**KIRKLEES METROPOLITAN COUNCIL
INVESTMENT & REGENERATION SERVICE**

**DELEGATED DECISION FOR APPLICATION FOR CERTIFICATE OF
LAWFUL DEVELOPMENT**

Reference no.: 2025/CL/92530/W

Description: Certificate of lawfulness for proposed hip to gable
roof

19020D-07-R02

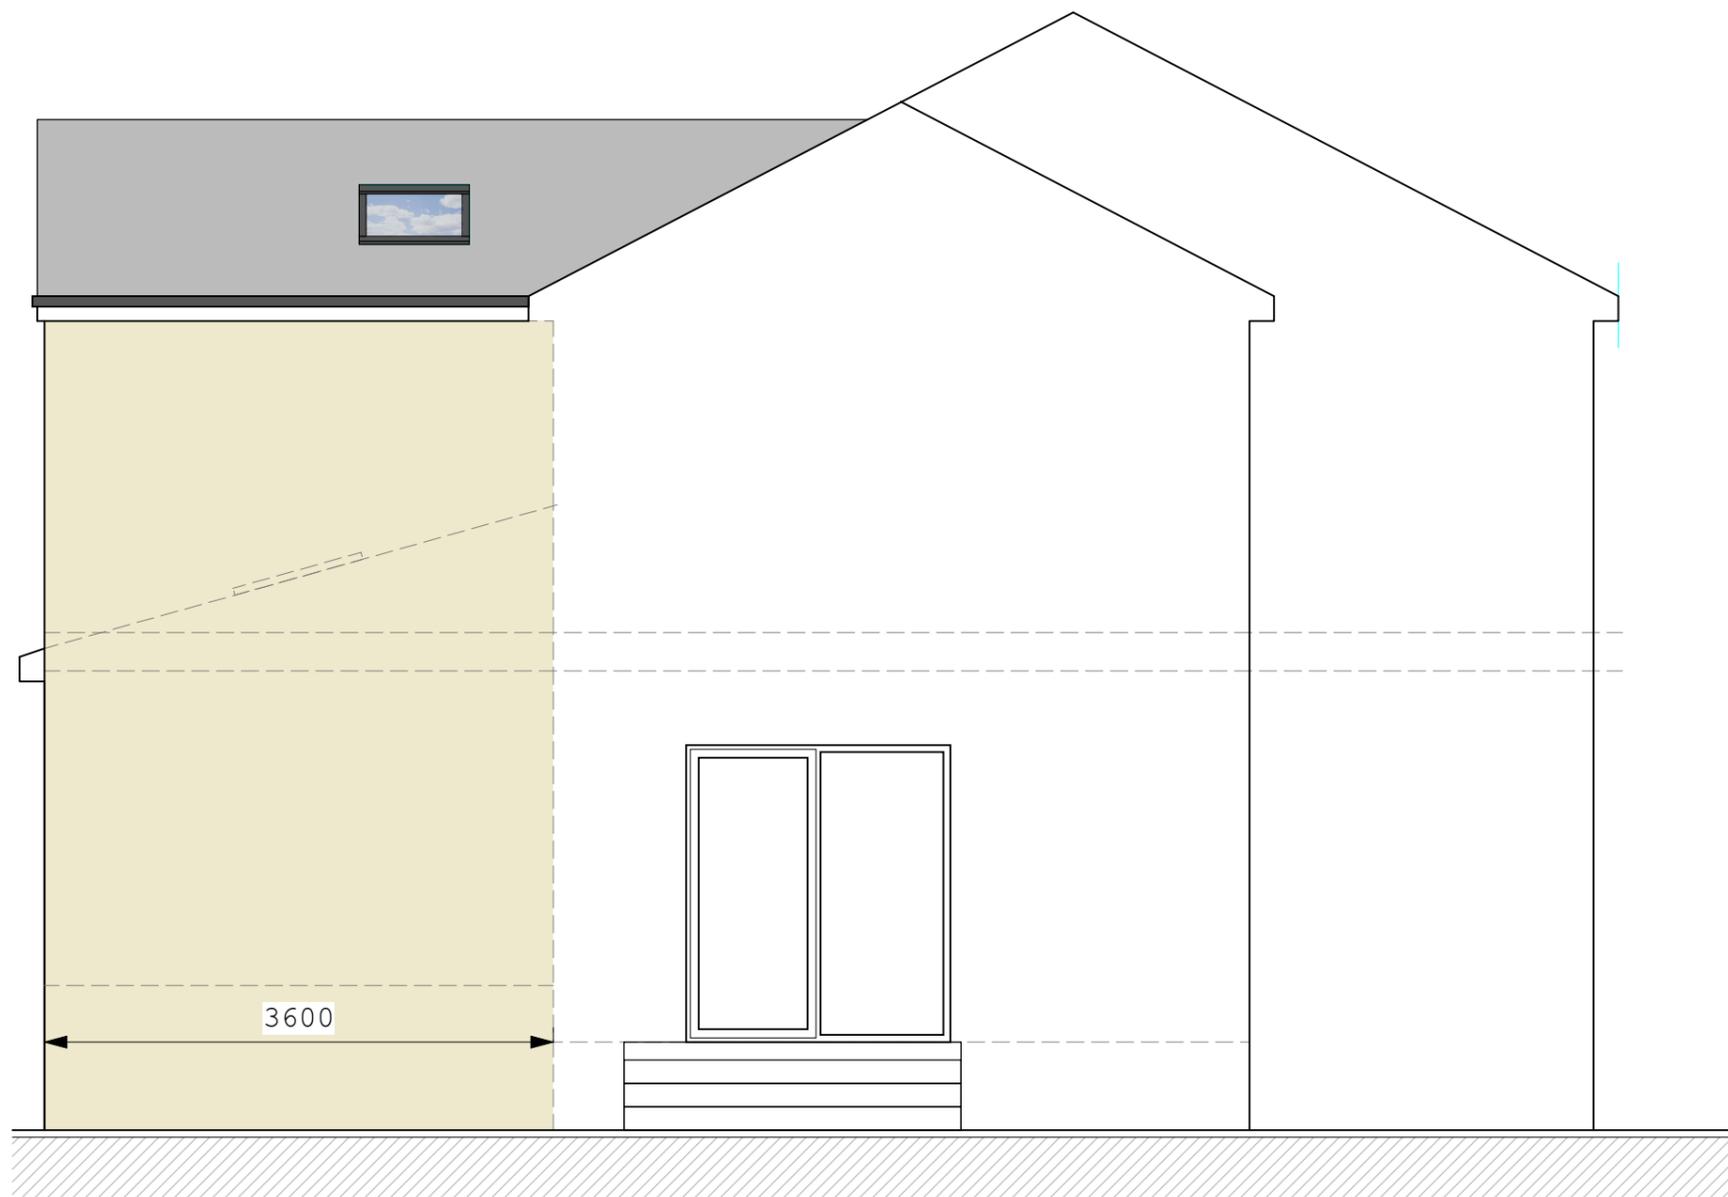
The submitted details indicate that a Certificate of Lawful Development is sought to alter the roof form of the two-storey extension from a hipped roof form to a gabled roof form.

Should the development implement a change in roof form prior to the extension being substantially complete (including the construction of the walls and roof form) which materially deviates from the approved plans then it cannot be deemed that the construction of the planning permission is being carried out in accordance with the approved plans and would, as such, be in breach of the original permission unless it can be demonstrated the 2019 development was completed in accordance with the approved plans. To exercise permitted development rights on an unlawful structure would be contrary to Article 3(5) of the Town and Country Planning (General Permitted Development) (England) Order 2015 (as amended).

undertaken providing that development does not exceed relevant limitations. However, this is not the case in this instance as the extension to be amended appears not to be complete at the time of this application and as such the application seeks to amend the design of the 2019 permitted development rather than extend an existing part of the roof.

Therefore, taking into account the evidence supplied within the application submission and that which is accessible to Officer's from Building Control records and public access imagery it cannot be concluded that the proposed works could be implemented by virtue of a Certificate of Lawful Development as the approved 2019 development does not appear to be substantially completed.

The proposed hip to gable alteration to plans pursuant to planning permission 2019/92352 does not benefit from a general planning permission under Article 3(1) and Schedule 2, Part 1, Class B of the Town and Country Planning (General Permitted Development) (England) Order 2015 (as amended) as the works would materially deviate from the partially completed approved development granted for a single and two storey extension thus contrary to condition 2 and Article 3(5) of the same Order.

Should the applicant wish to alter the roof form of the development pursuant to permission 2019/92352 prior to the planning permission being substantially completed, it is advised that a new planning permission is obtained, or a Section 73 application is submitted to vary the submitted plans under Condition 2 of the decision notice.
